DECISION DELEGATED TO HEAD OF PLANNING

Application No:	H02-0462-23	Applicant:	Mr I Owen
Proposal:	Demolition of existing single storey side extension, proposed extension to create bedroom and shower room and conversion of existing garage into home office space.		
Location:	33 Postland Road Crowland Spalding		
Terminal Date:	13th July 2023

CASE OFFICER ASSESSMENT

PART GROUND FLOOR PLAN  
(AS PROPOSED)

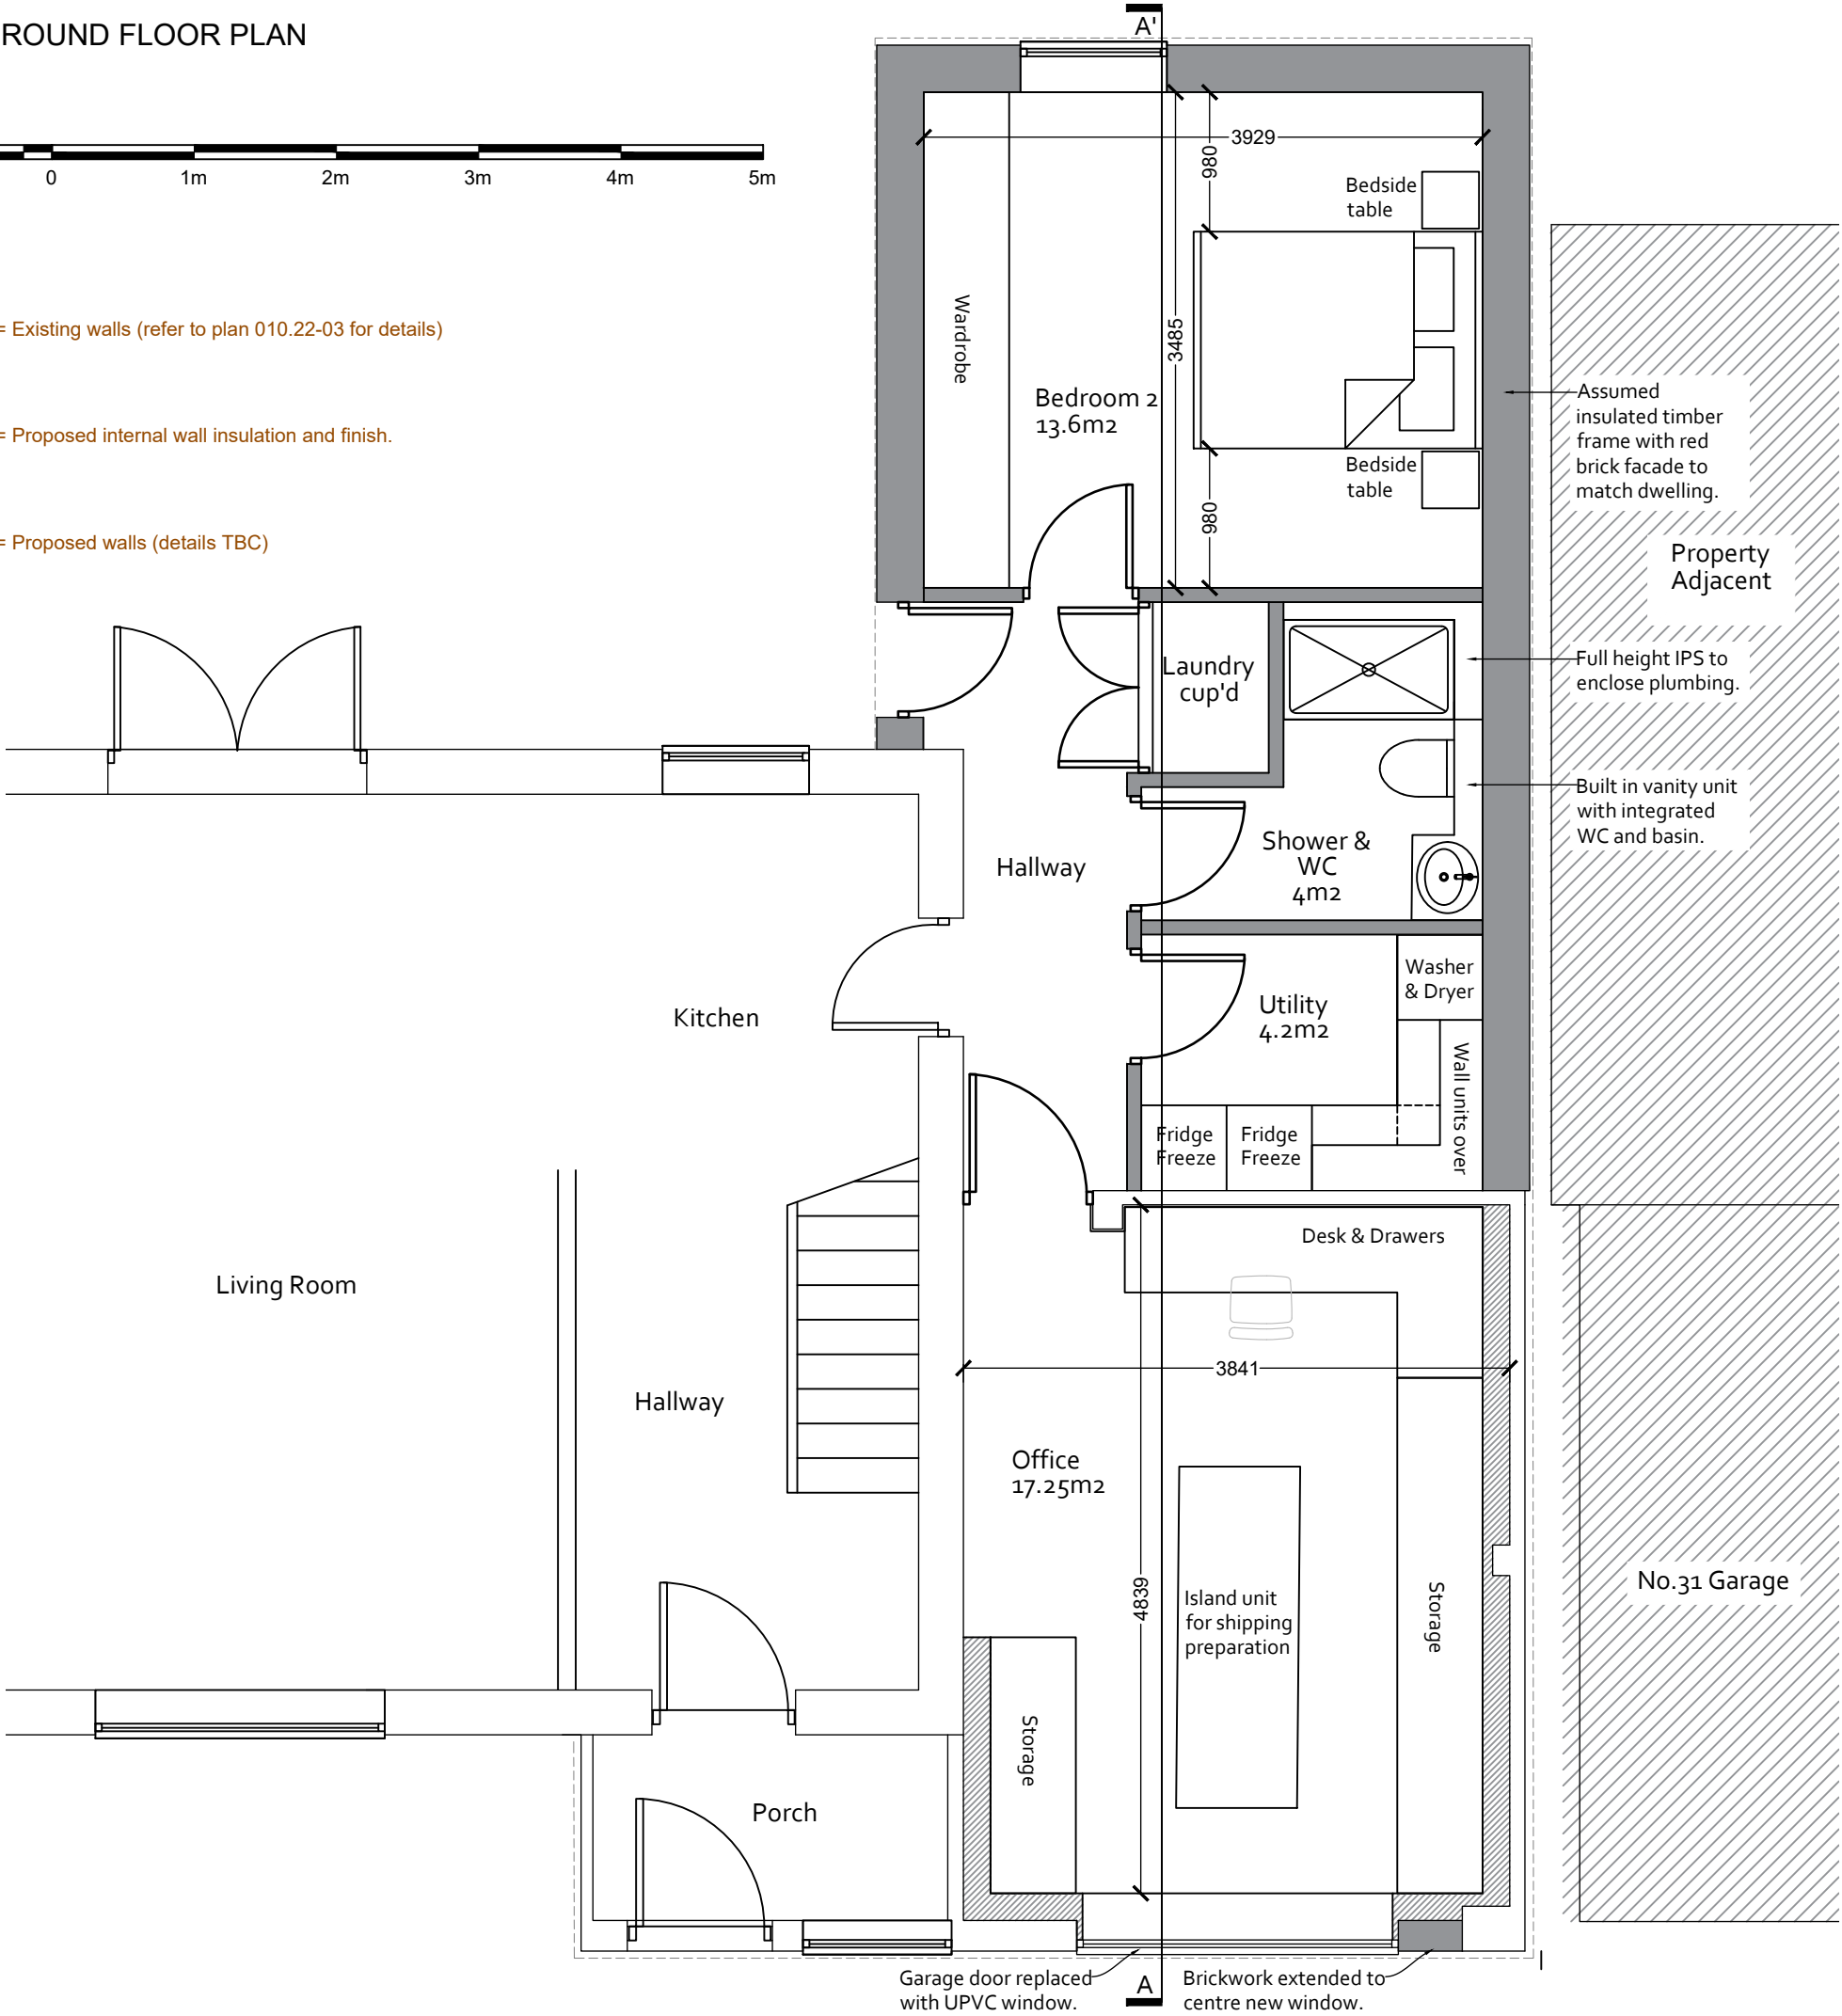
There will be some alterations taking place as part of the proposal, at the front of the property they will be replacing the garage door with a uPVC window and extending the brickwork to reduce the opening width. This will be to allow natural light into the home office space. A first floor window will be replaced to allow for roof flashing to waterproof sections of the extension. At the rear in the proposed extension there will be a utility, shower room & WC and a bedroom. In this section the wall will be brought away from the neighbouring party wall and create their own wall, there will be a gap of around 0.1m between these boundaries.

ROOF PLAN
(AS PROPOSED)

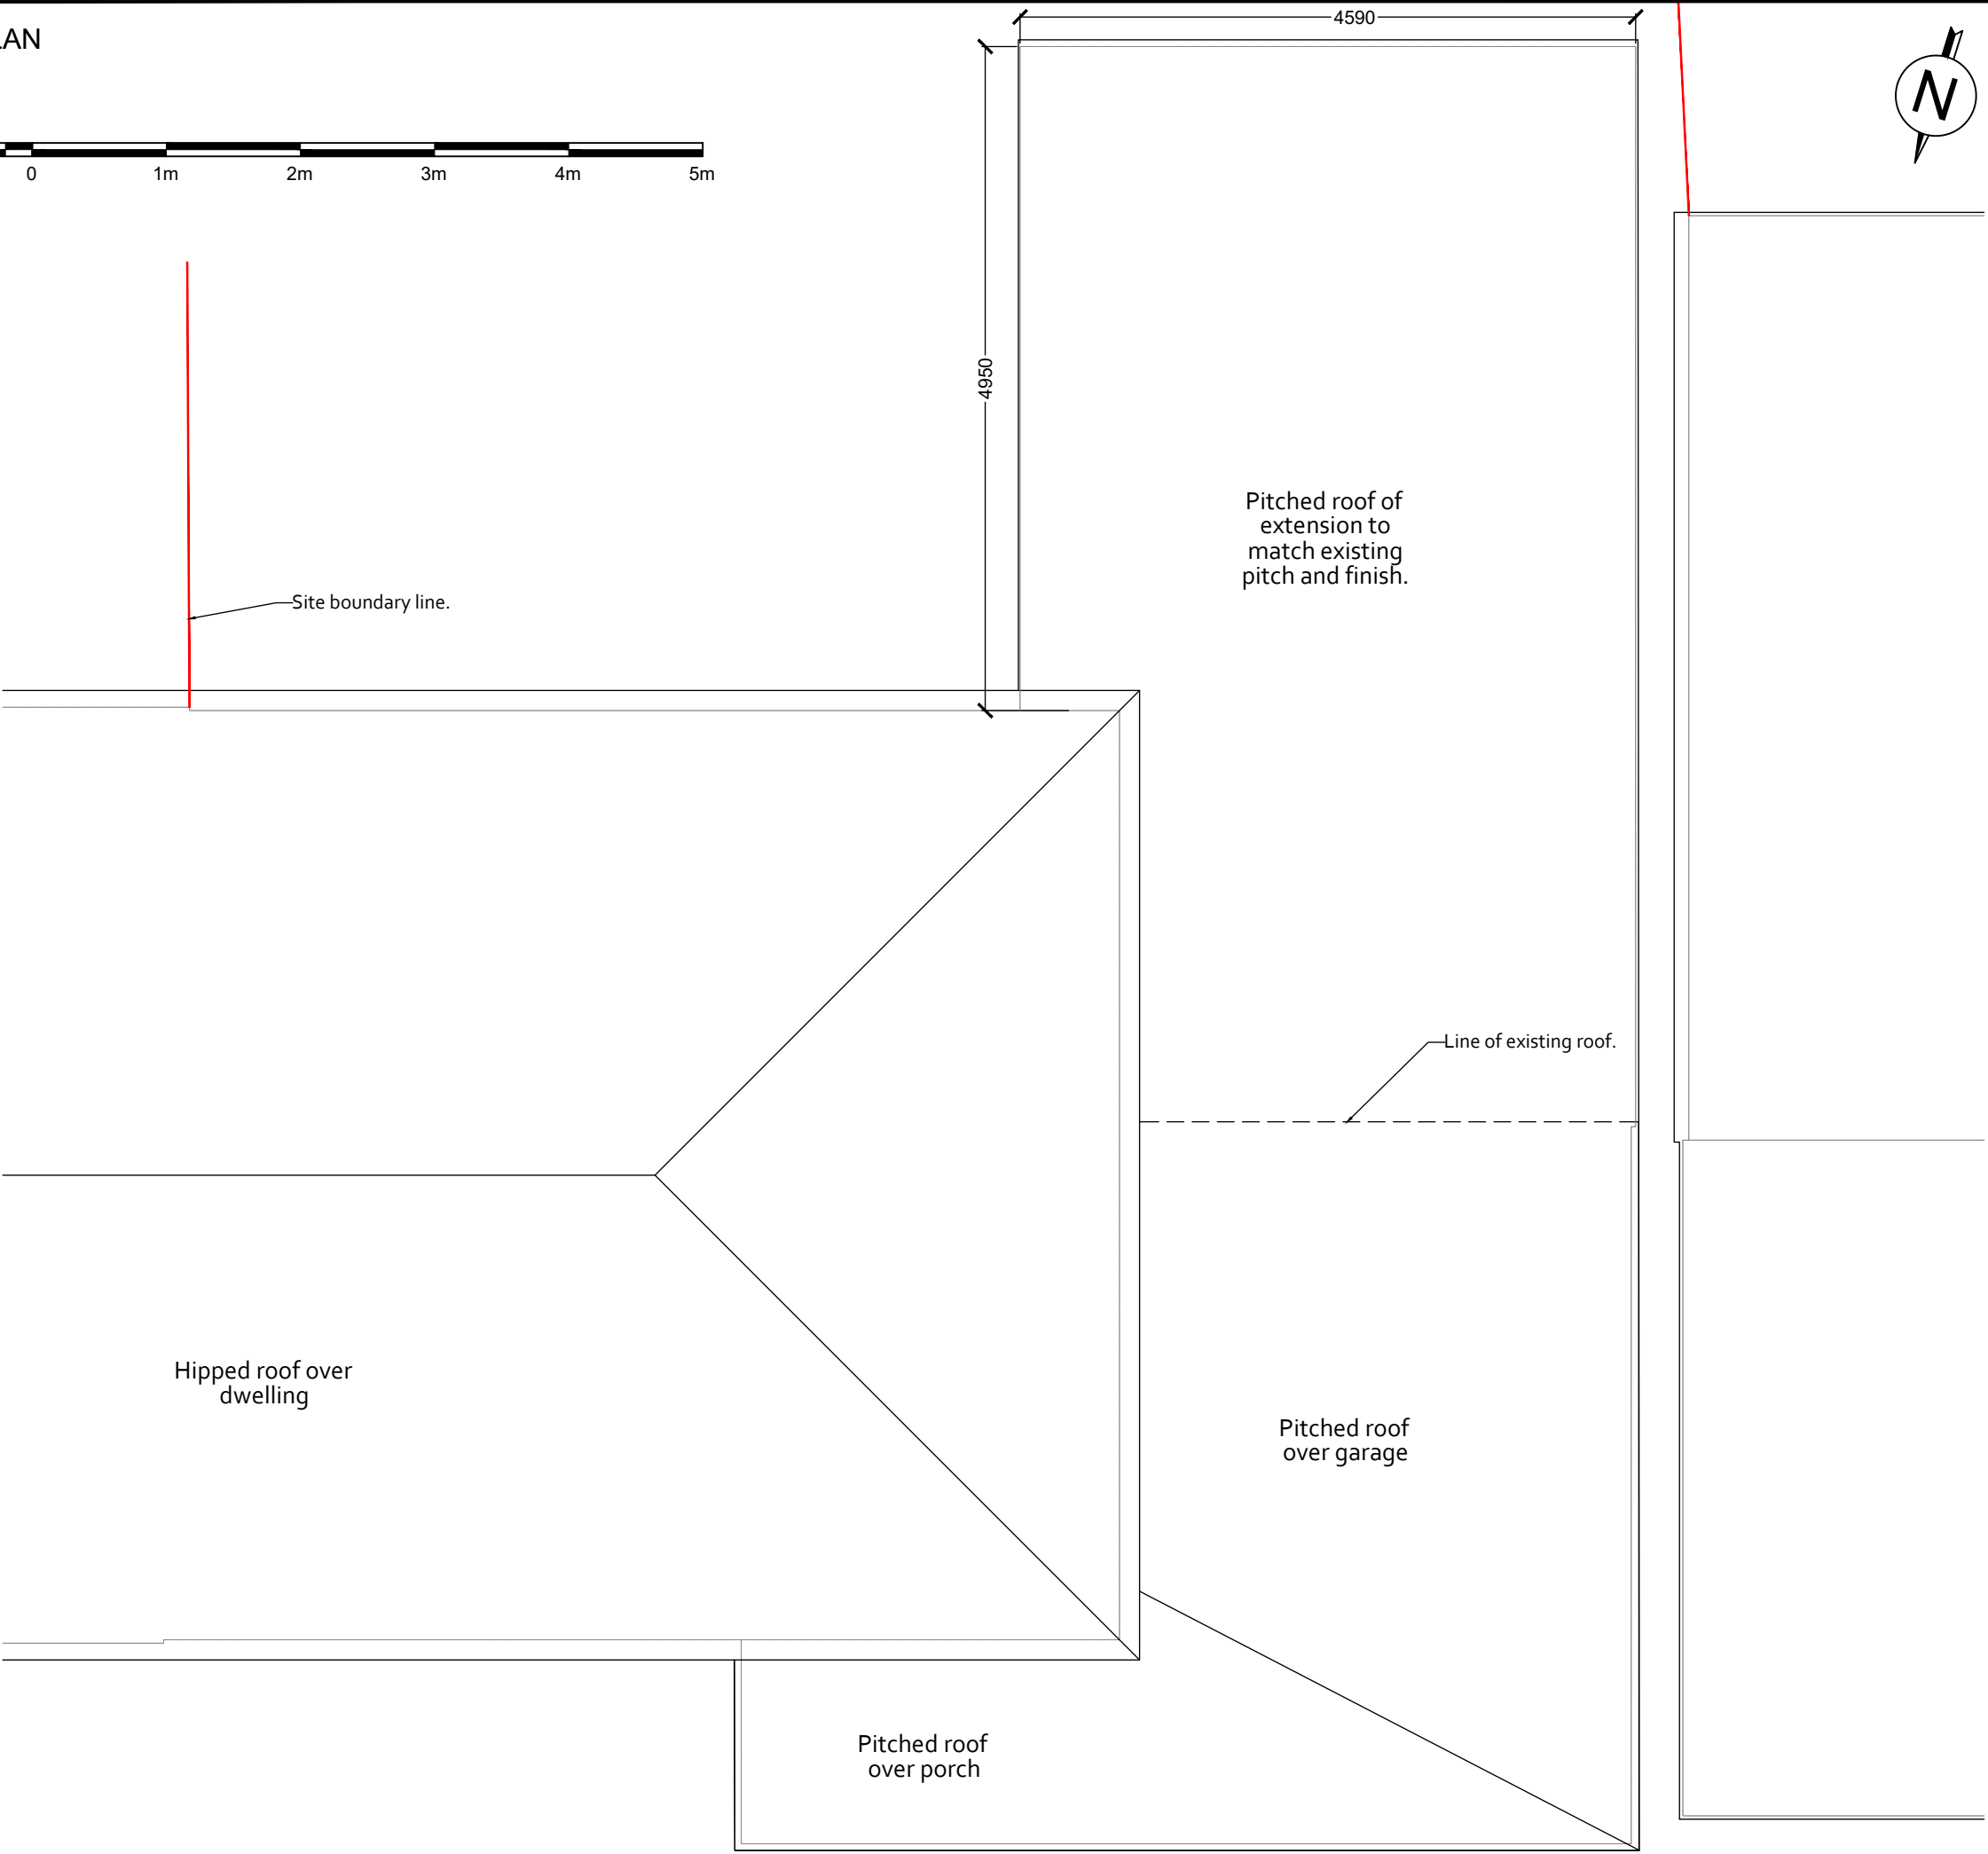
"The fall of the roof of our outbuilding falls running parallel, we need to make sure that the demolition of the existing structure and construction of the new extension is to install a cladding panel along the verge of our roof where it currently butts up to the neighbours current flat roof. There still may be Party Wall issues which may need investigating to ensure that our outside wall on the boundary is structurally sound and enclosed following removal of the current building".

Request that a condition be added to the application to *"Ensure that proper investigation is undertaken and satisfactory construction details are provided"*.

A resident raised a comment regarding the adjoining party wall and wanted to ensure that this would be structurally sound following the new development. After confirmation from the Agent a structural engineer will be appointed to carry out the design of the proposed extension including necessary remedial works to the existing party wall. Notice will be served under the party wall act prior to works commencing and the demolition of the structure adjacent to the party wall will take place once its interface has been exposed so that risk can be managed. This will help minimise impact on the neighbouring property. Overall, it can be considered that this is therefore safe.

SECTION A-A'
(AS PROPOSED)

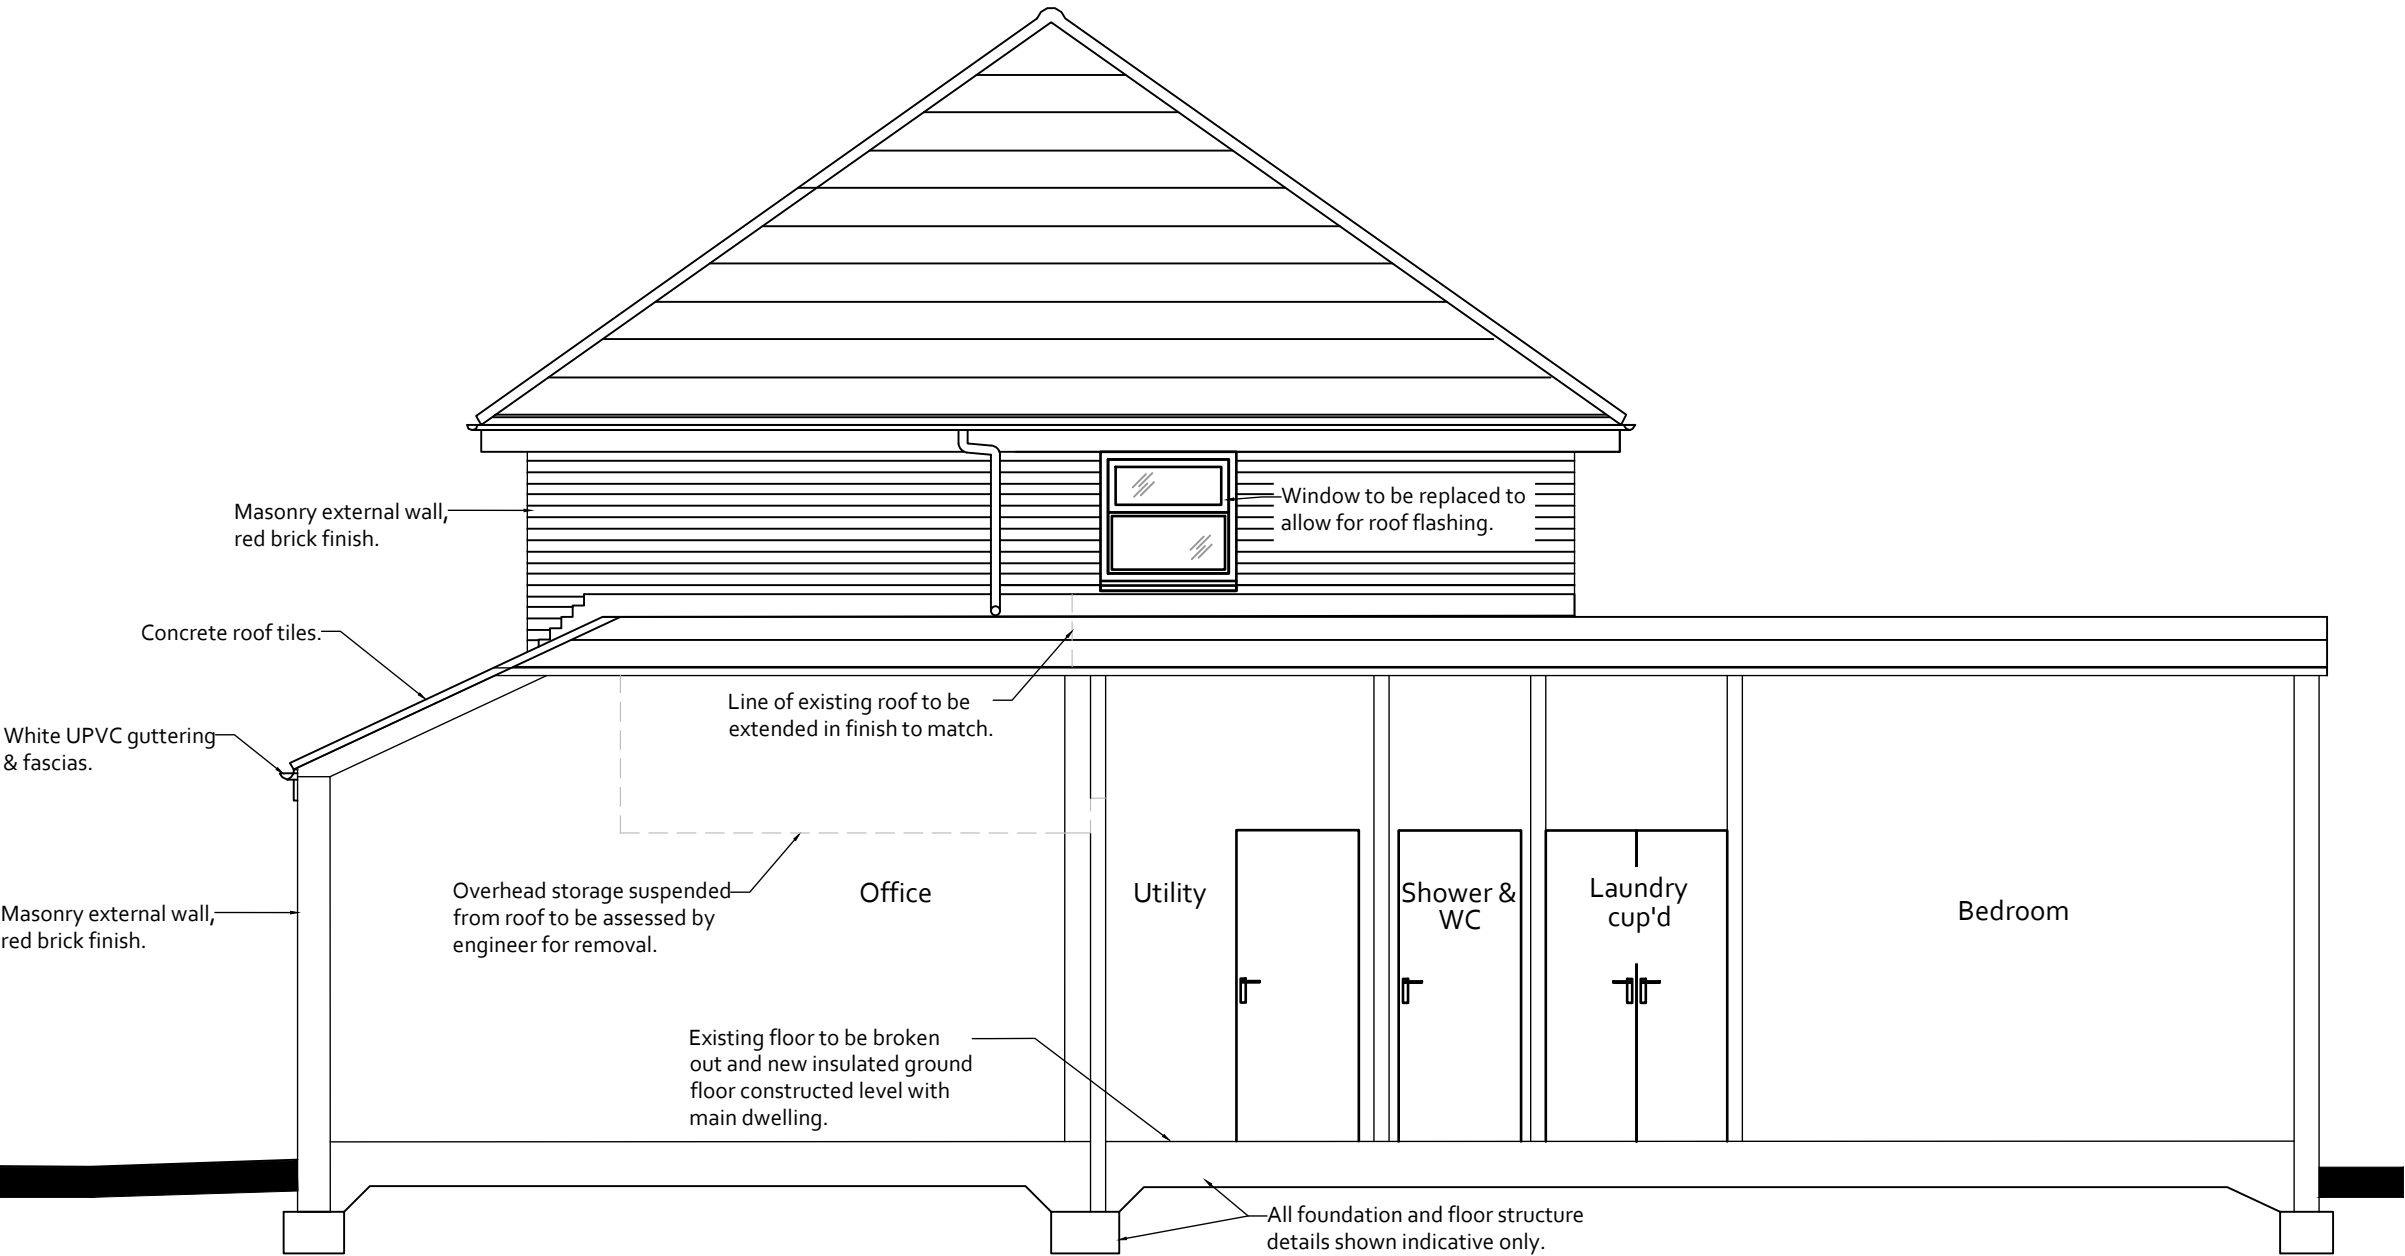
This is a householder application seeking permission to demolish existing single storey side extension and proposed extension to create a bedroom and conversion of existing garage into home office space. The extension will be the same height as the existing extension is and will be of a similar length and width but is slightly longer at the rear.

As the development is of a similar size for height, width and length it will ensure that no new issues regarding overshadowing happen. It is only slightly longer at the rear than compared to the existing extension and this isn't big enough to drastically impact the area or any neighbours. Due to the positioning it won't overshadow to the front or rear and there is adequate distance to No. 35 at the east. The neighbour on the west already has an existing outbuilding which is also of a similar height and therefore they will not be impacted.
